Aquind Interconnector application for a Development Consent Order for the 'Aquind Interconnector' between Great Britain and France (PINS reference: EN020022)

Mr. Geoffrey Carpenter & Mr. Peter Carpenter (ID: 20025030)

**POST HEARING NOTE IN RELATION TO ORAL REPRESENTATIONS RELATING TO
SCOPE OF AUTHORISED DEVELOPMENT DELIVERED DURING COMPULSORY
ACQUISITION HEARING 2 AND REDUCTION OF LAND TAKE**

Submitted in relation to Deadline 6 of the Examination Timetable

DRAWING NO: EN020022-ES-24.2-Sheet1	REV.NO. 01
---	---------------

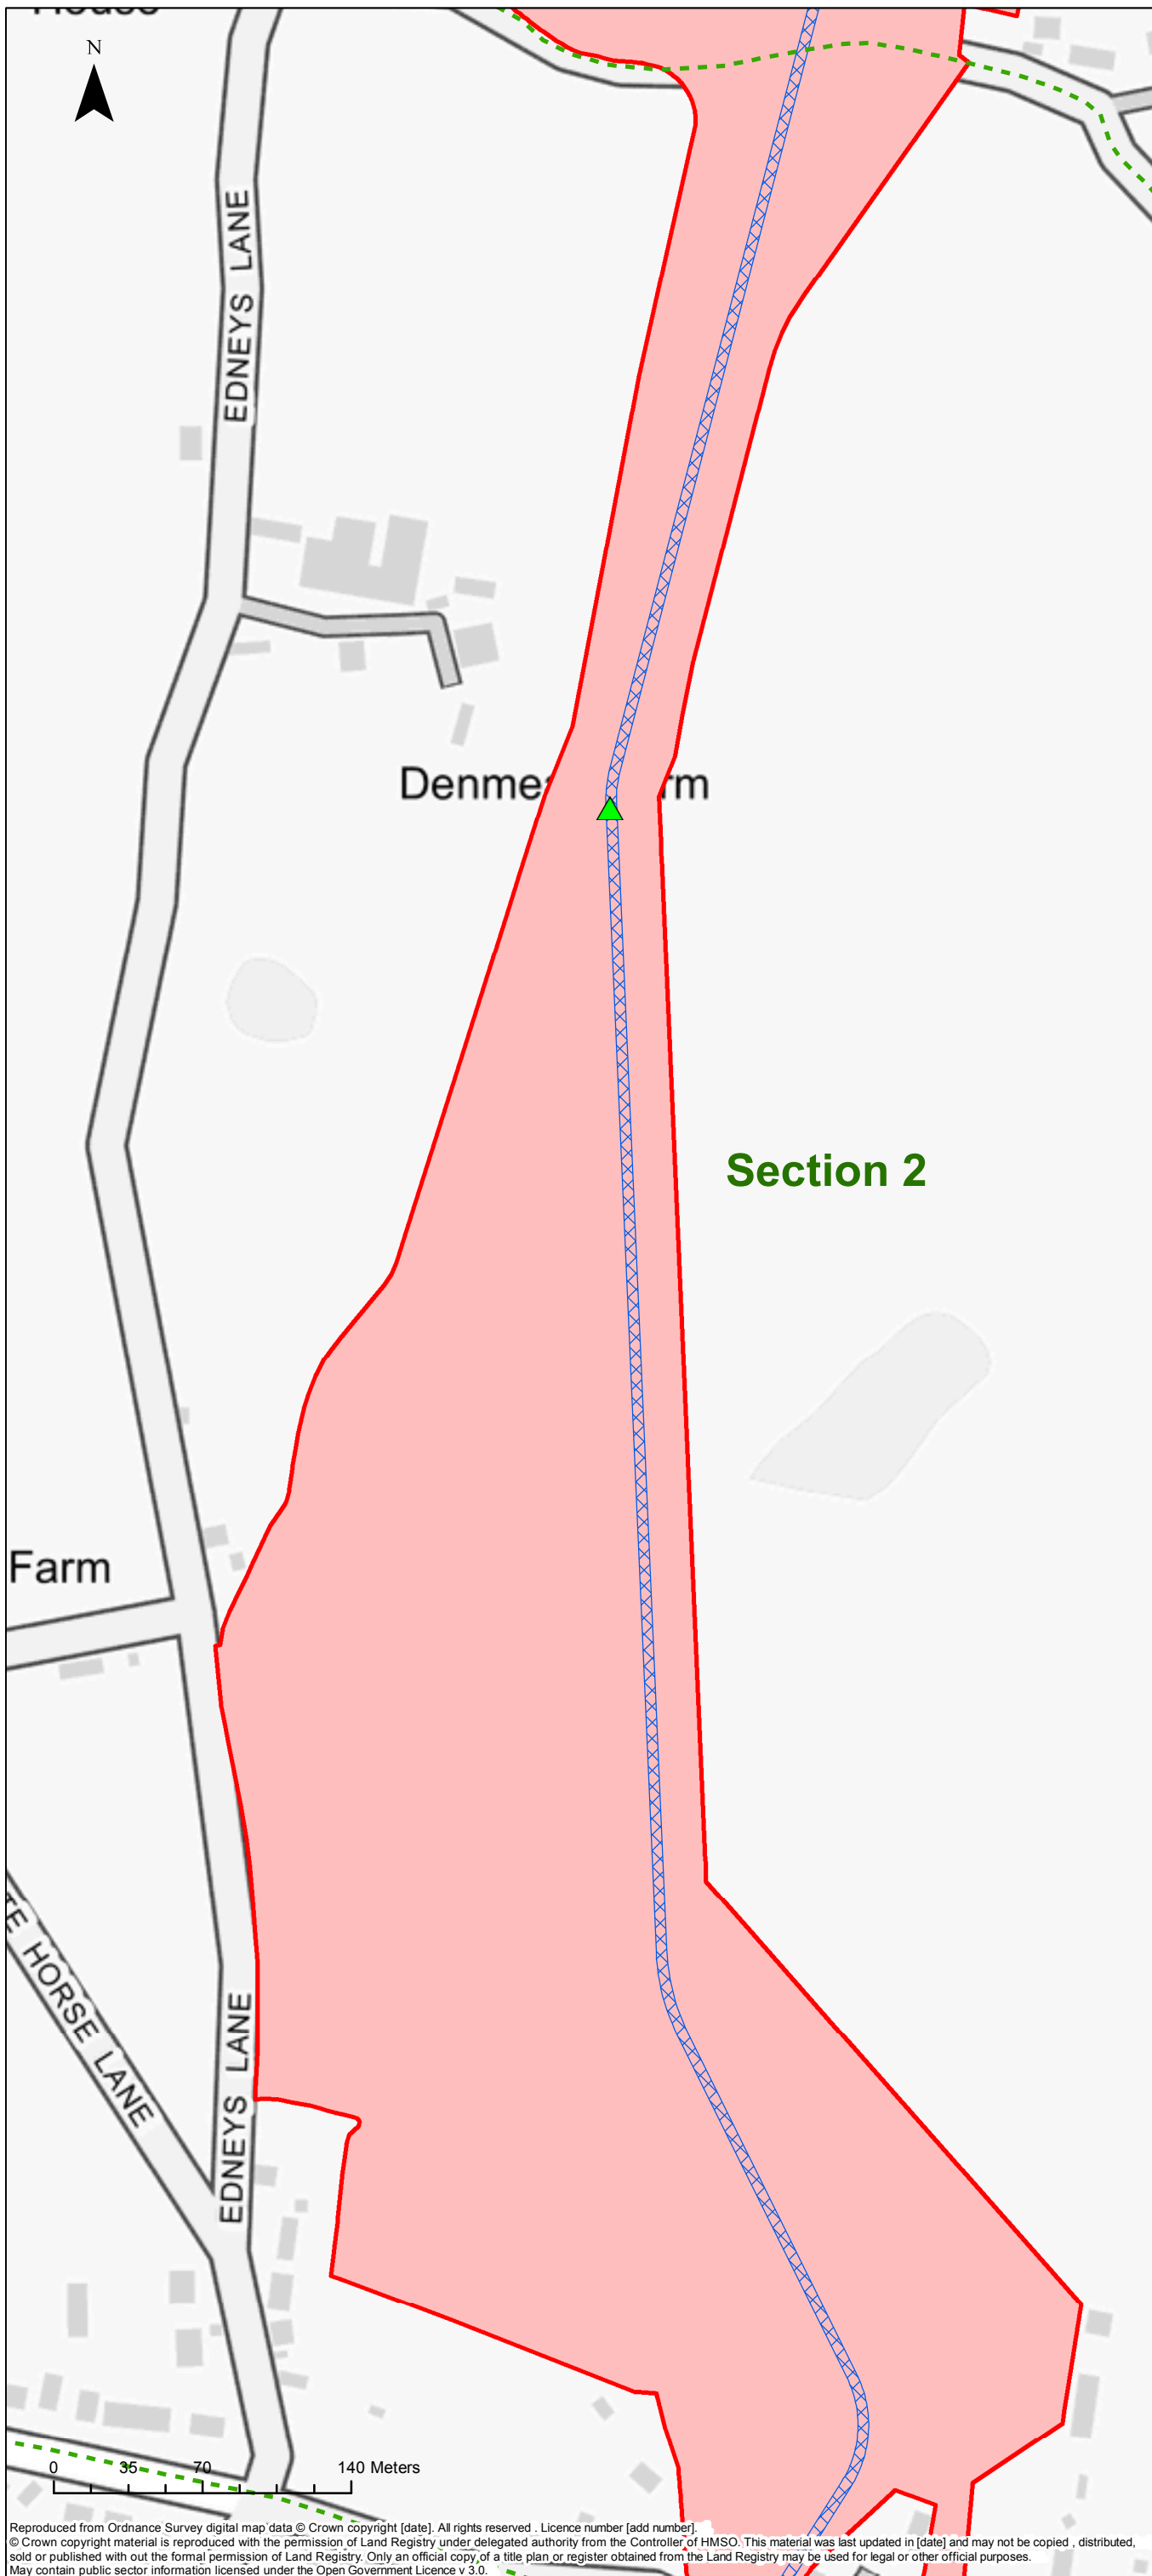
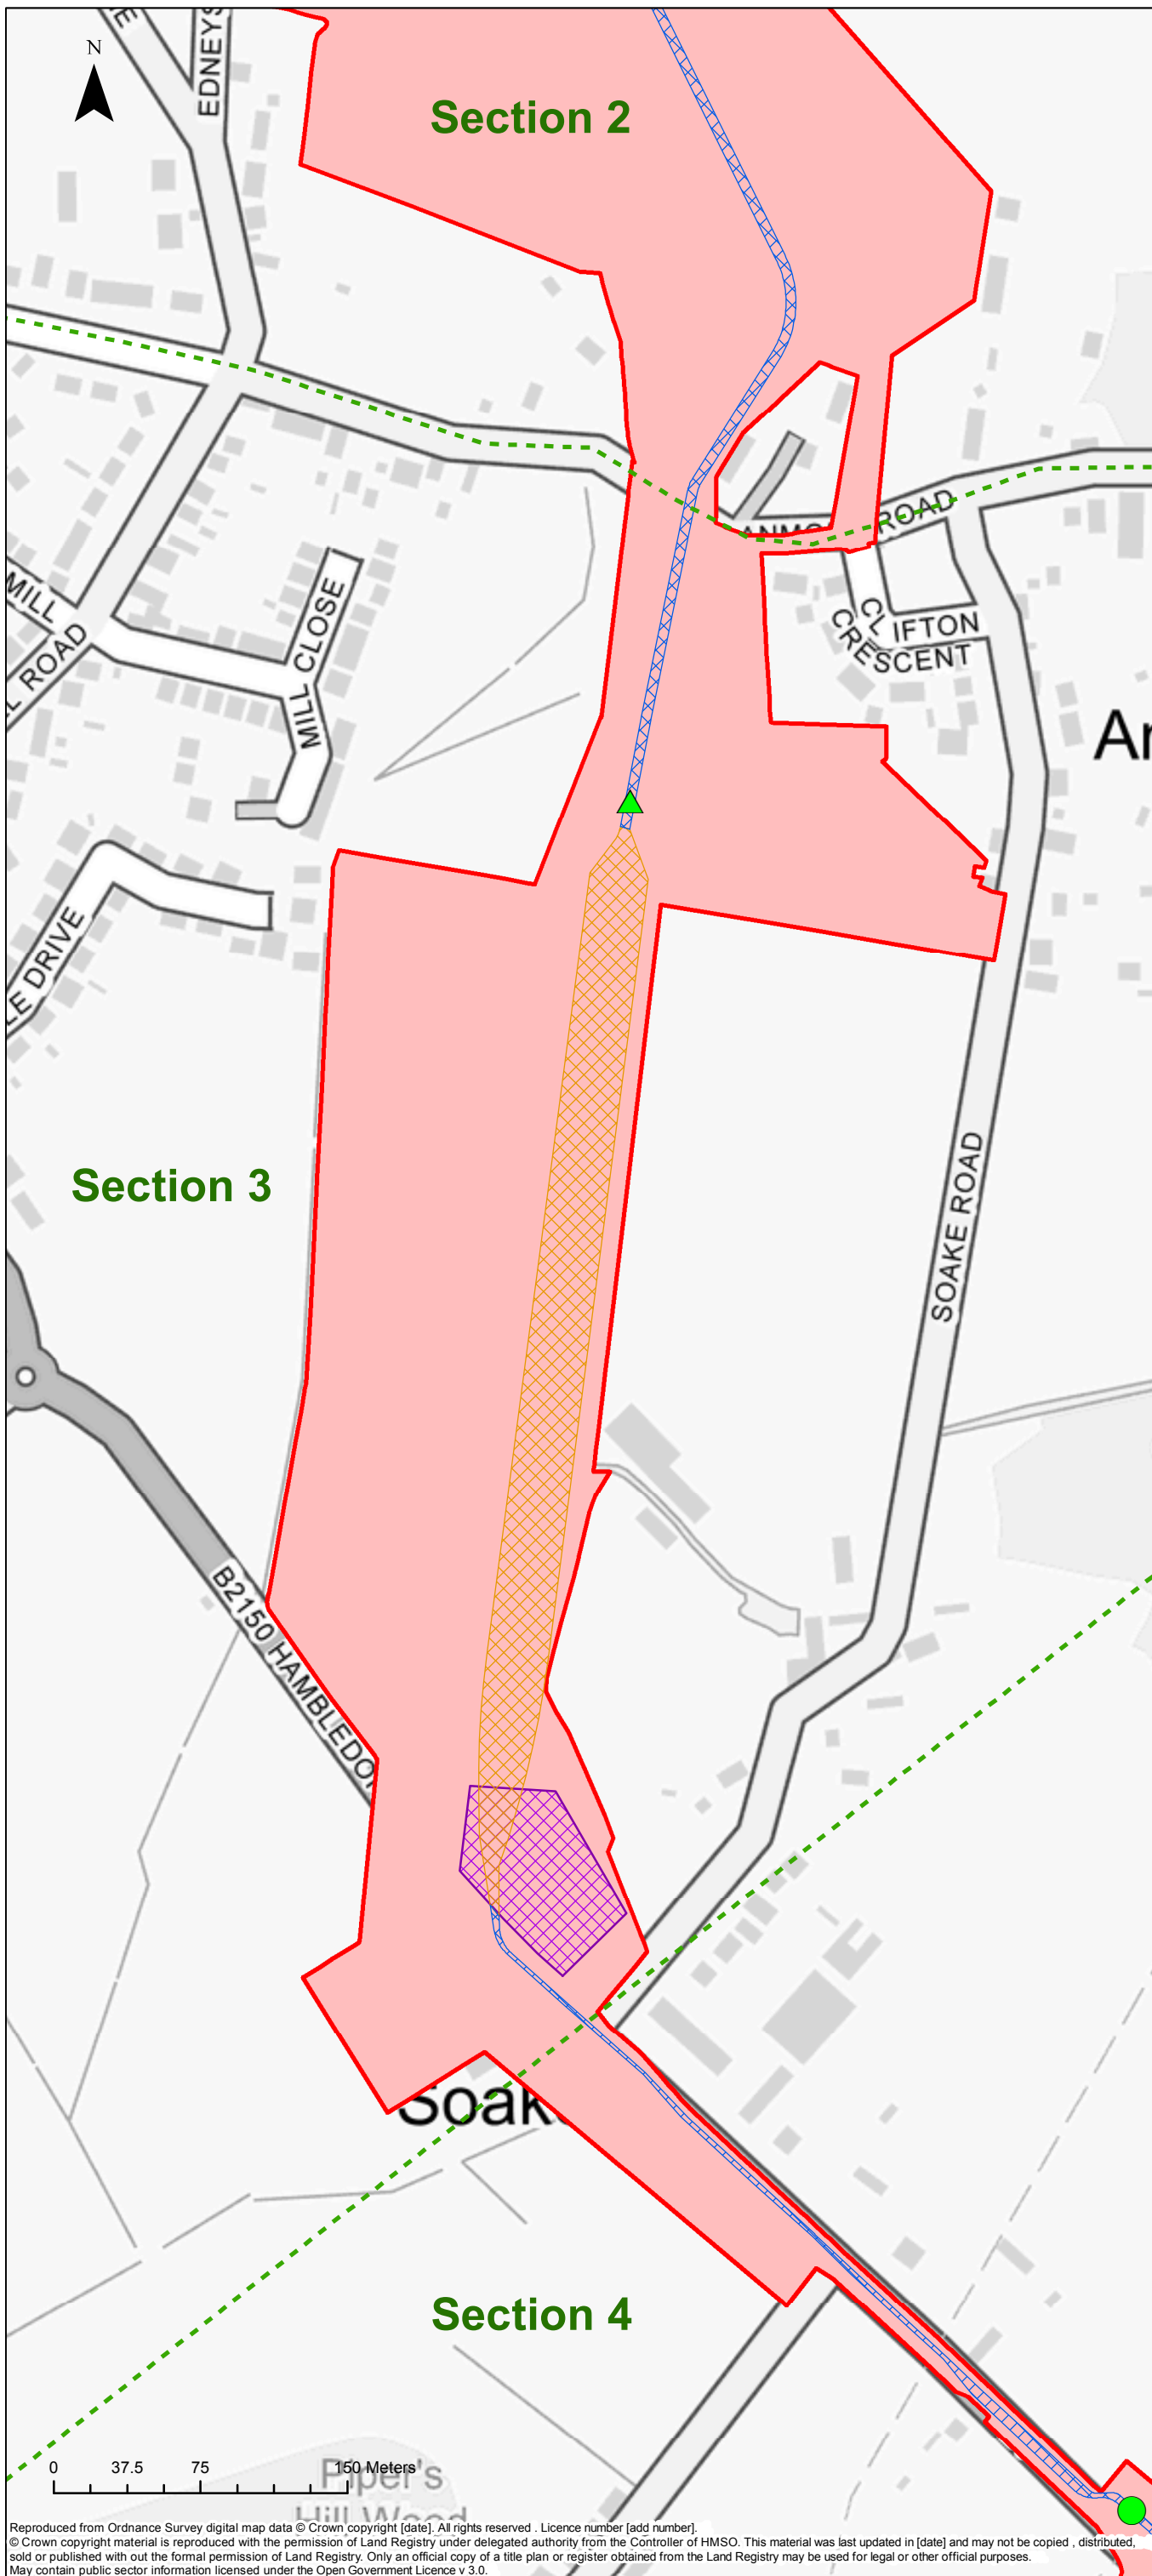
13. As it traverses the land of the Affected Party, Figure 24.2, Sheets 1 and 2 show the envisaged "trenching – illustrative alignment" of the pairs of cables in ducts as they might traverse the land of the Affected Party from the nearest "joint bay" south of that land. See "Order limits" outlined in red on [APP-336], Figure 24.2 and Sheet 1, Section 1 attached hereto for convenience at **Appendix NSPAD 9**. Figure 24.2 has a scale in metres (not millimetres). The envisaged on-shore cable route for 6 x cables (4 x 140mm diameter, and 2 x 30-55mm diameter) is envisaged to be situated anywhere within the 'sea of red' coloured land shown within the parameter engendered by the Order Limits themselves. Whilst Figure 24.2, Sheet 1 "illustrates" a trenching alignment in blue cross-hatch, no parameter requires adherence to that merely illustrative route, no clear co-ordinates define the centre line of that route, and no parameters confine the width or depth or extent of that route. Rather, cables may be situated anywhere within the sea of red. However, comparison of that sea of red with the land of the Affected Party shows that the greater extent of its land would be within the Order limits red sea. Such *desired* flexibility of wide land take for relatively tiny diameter cables (the largest no more than a mere *hand span* in diameter) is rationally difficult to follow or justify. See Advice Note 9.

14. Figure 24.2 appears to reflect constraints shown on Sheets 2 and 3 of [APP-013] 2.7 Indicative Converter Station Area Layout Plans. See Key showing "exclusion zones" in cross-hatched blue West and North of the Little Denmead Farm buildings. For example, a south-west to north-east diagonal break in that hatching reflects a similar alignment in the same location as the cross-hatched blue trench alignment illustrated in Figure 24.2, Sheet 1 on the land of the Affected Party.

Figure 17.2: Agricultural Land Classification

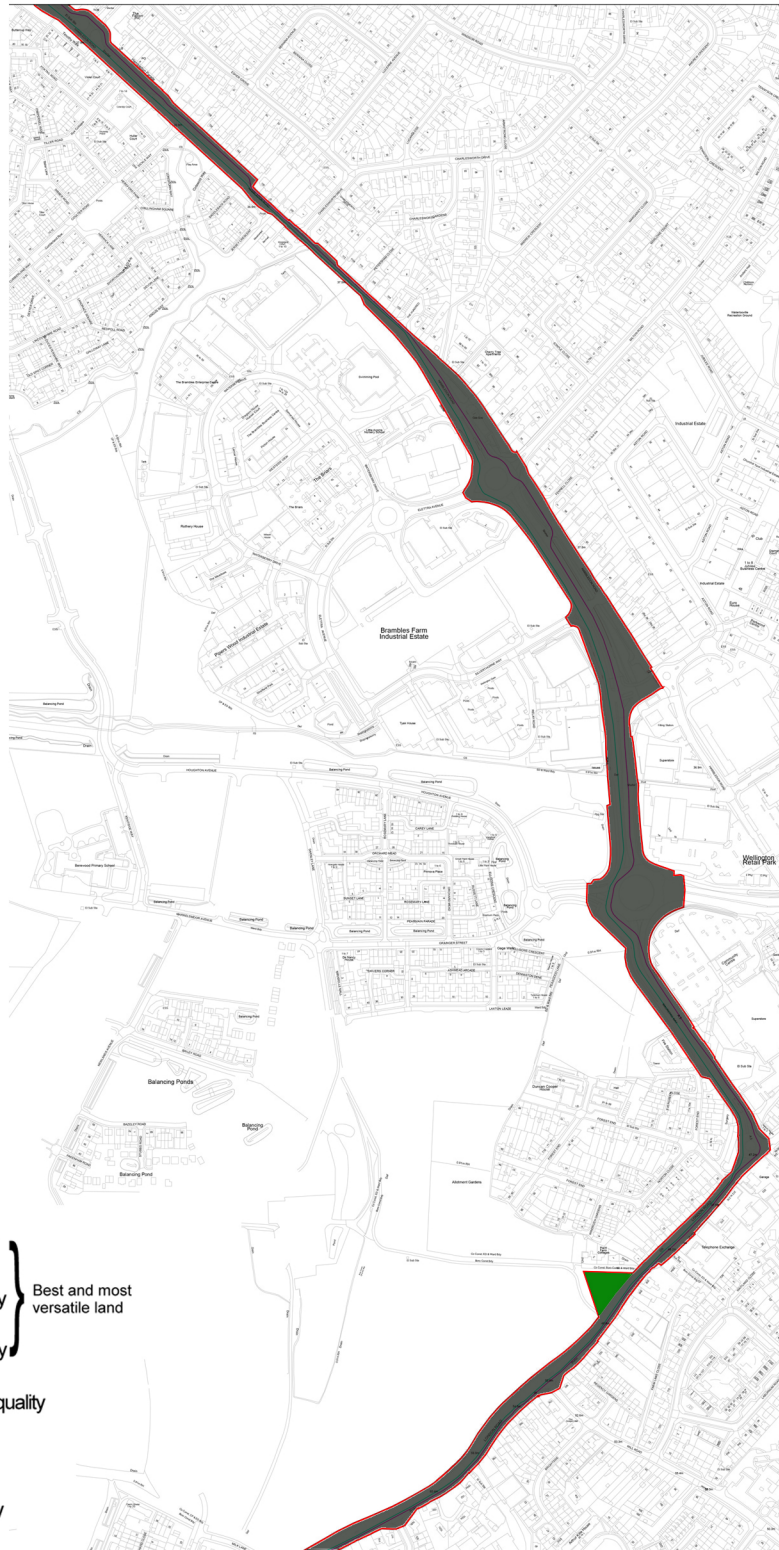
8. The Land of the Affected Party is shown on: Sheet 1 of Figure 17.2 of [APP-295] and Figure 17.2 of [APP-426] 6.3.17.2 Environmental Statement - Volume 3 - Appendix 17.2 Agricultural Land Classification and Soil Resources; and on the Land Registry Plans in its Written Representations (attached for convenience at **Appendices NSPAD 1-3**). The Design and Access Statement, Rev 02, at [REP1-132], explains:
